**Subject:** Rezoning Petition Review

**Date of Review:** April 28, 2022 (*Revised June 29, 2022*)

**Rezoning Petition #:** 21-270

**Recommendations  
Concerning Storm Water:**

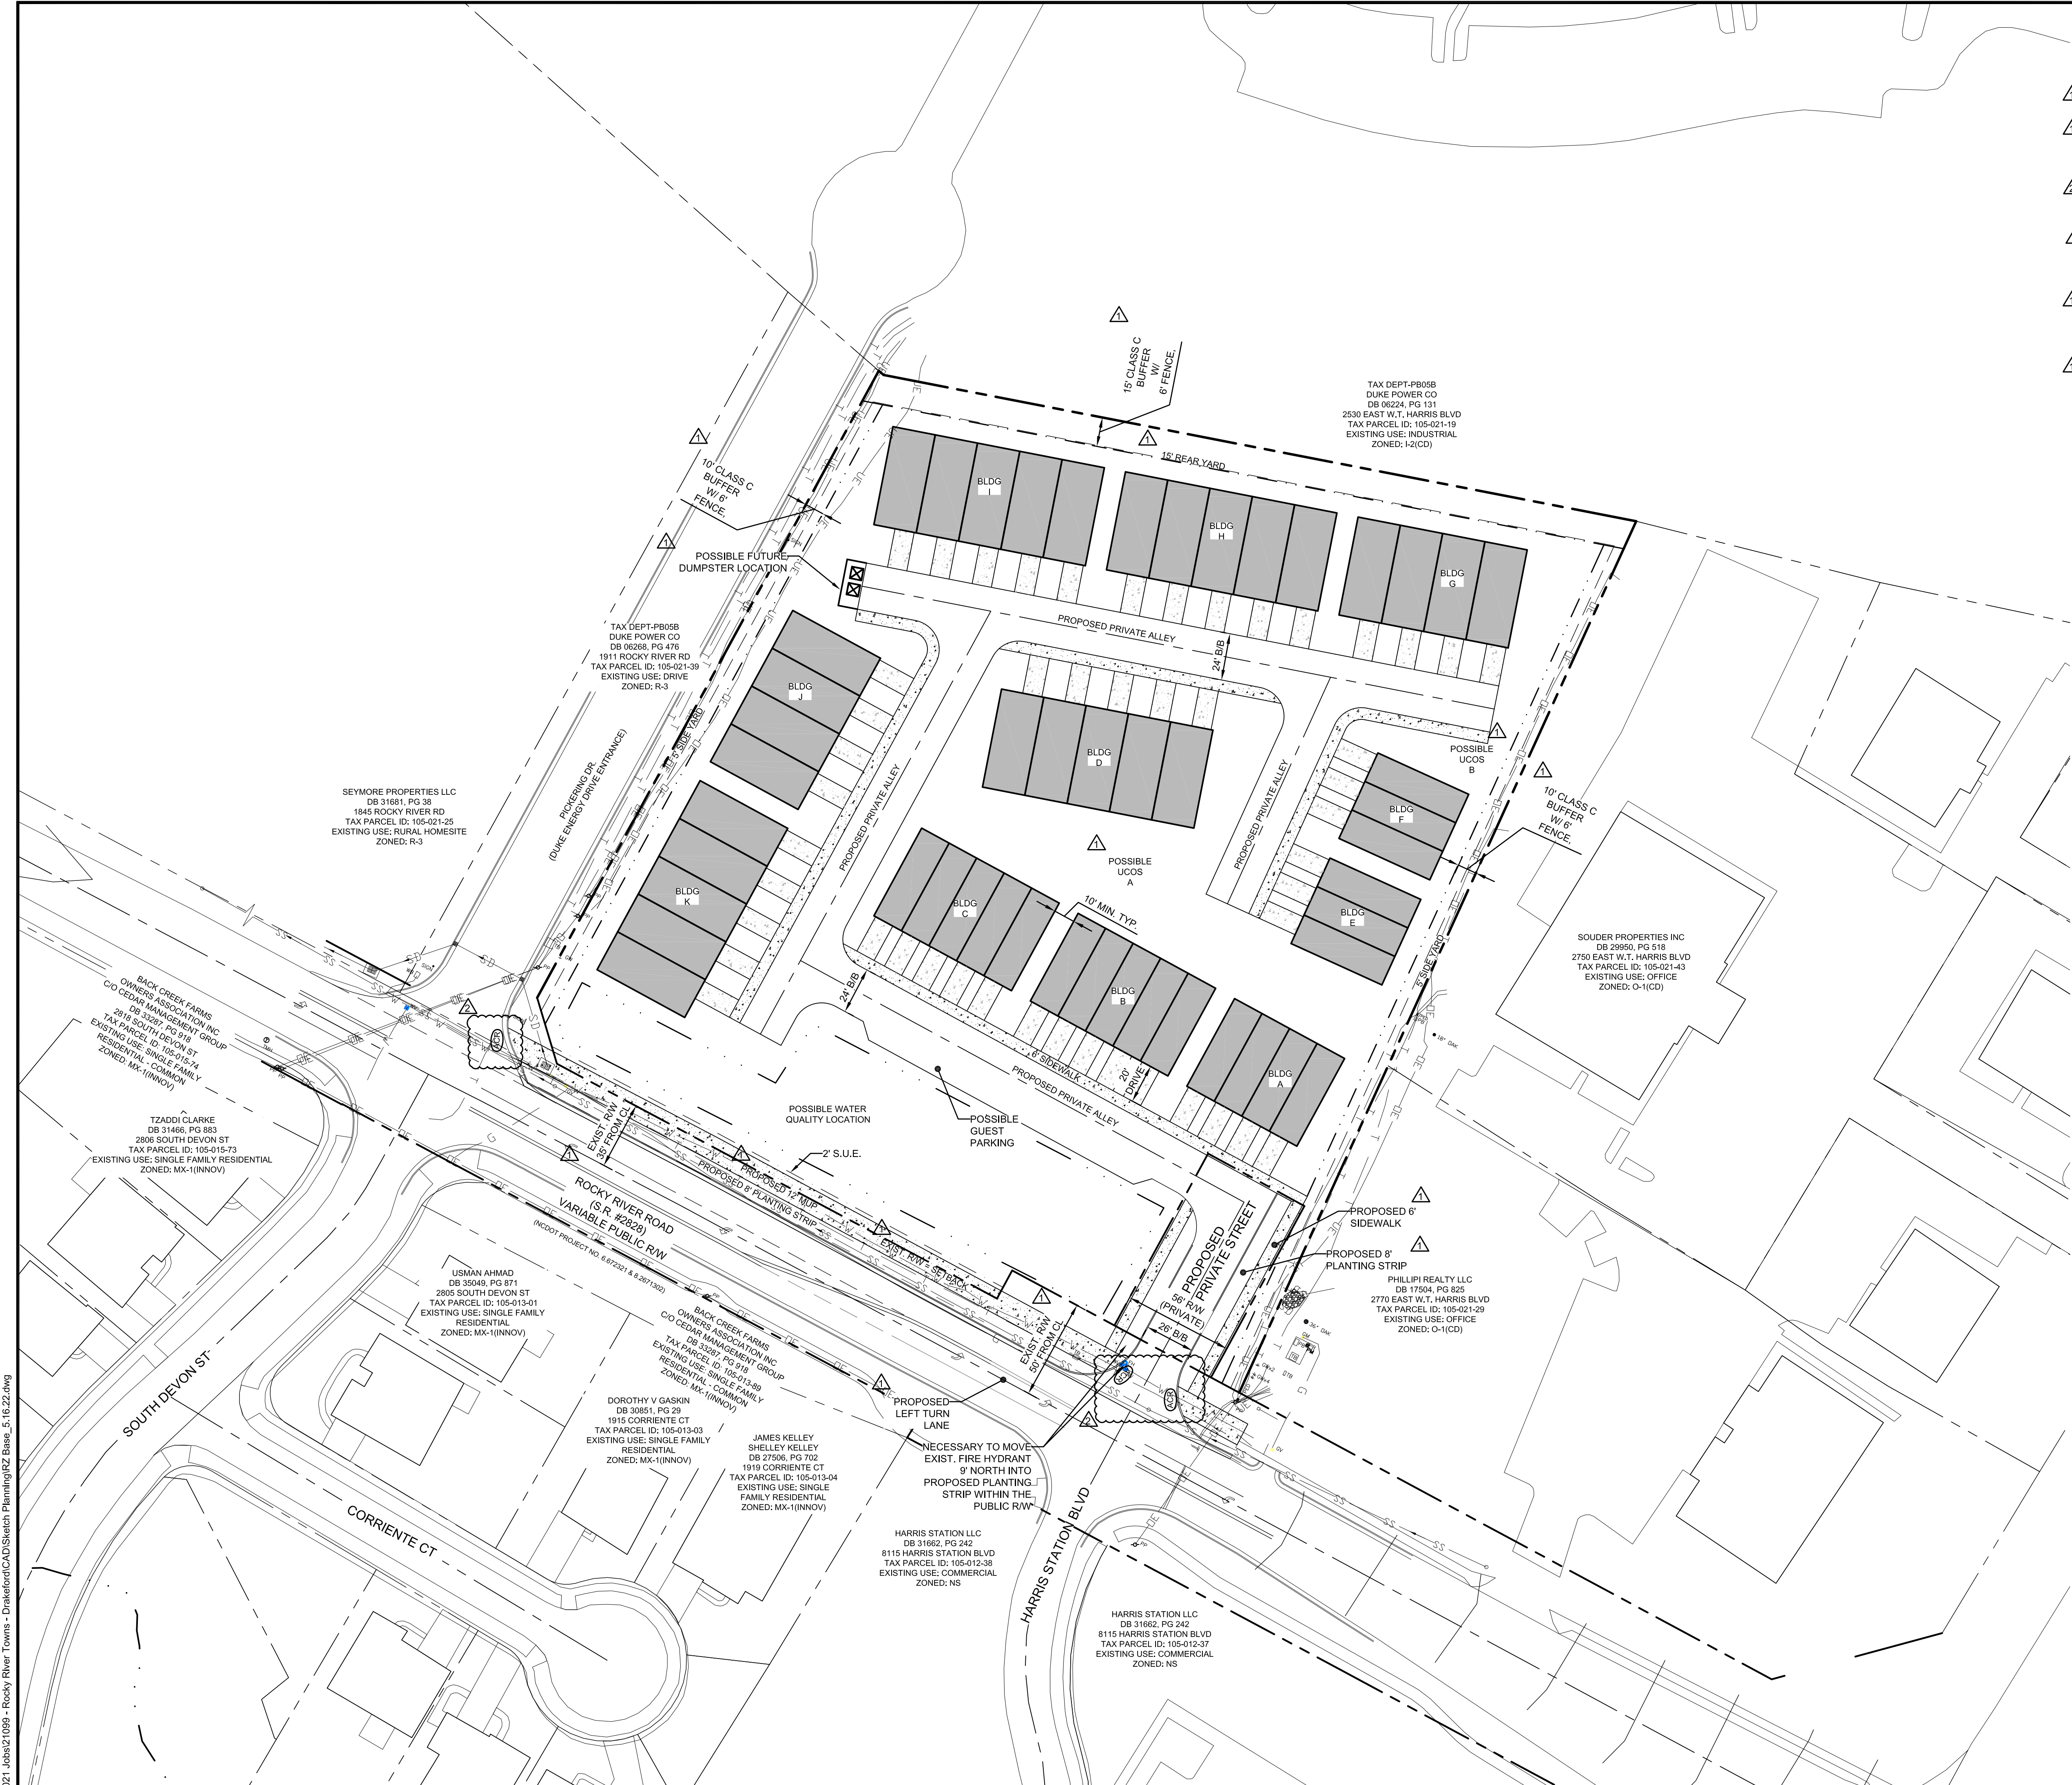
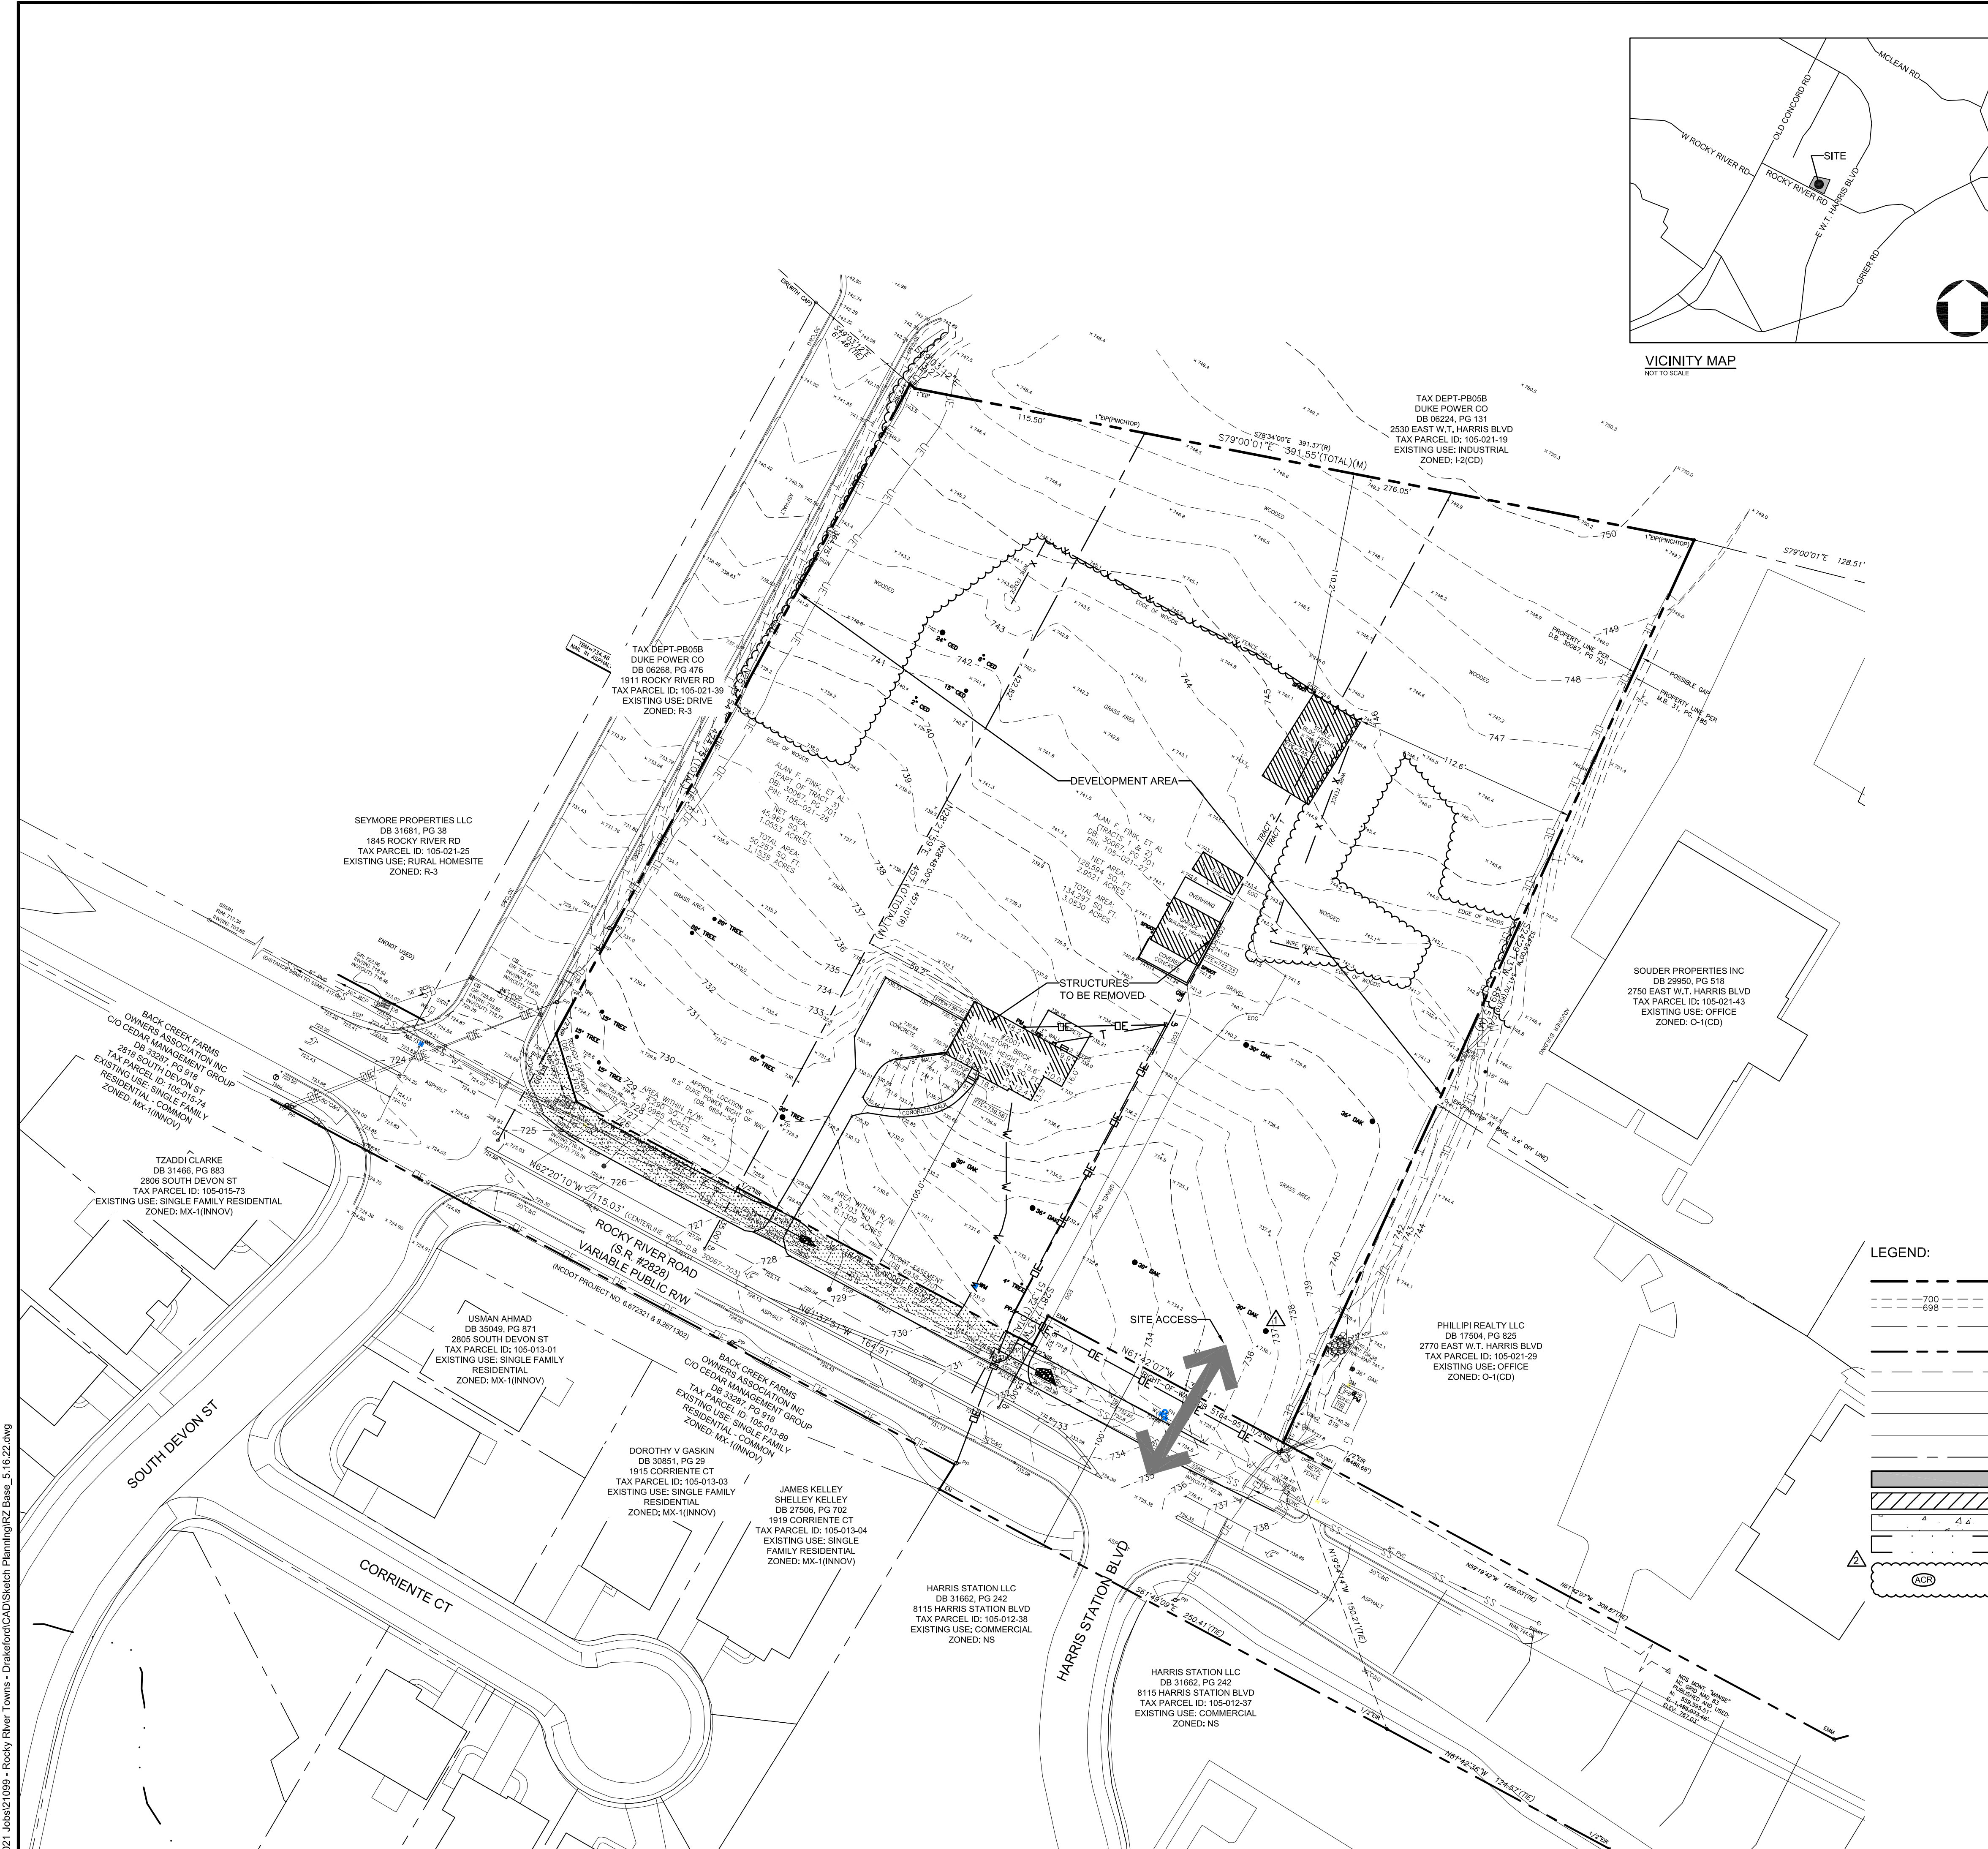
Please remove note 5 under "Environmental Features". Vegetation and landscaping requirements for storm water control measures are not approved with the rezoning process. These are based on the BMP Design Standards Manual, including the planting type, spacing and placement.
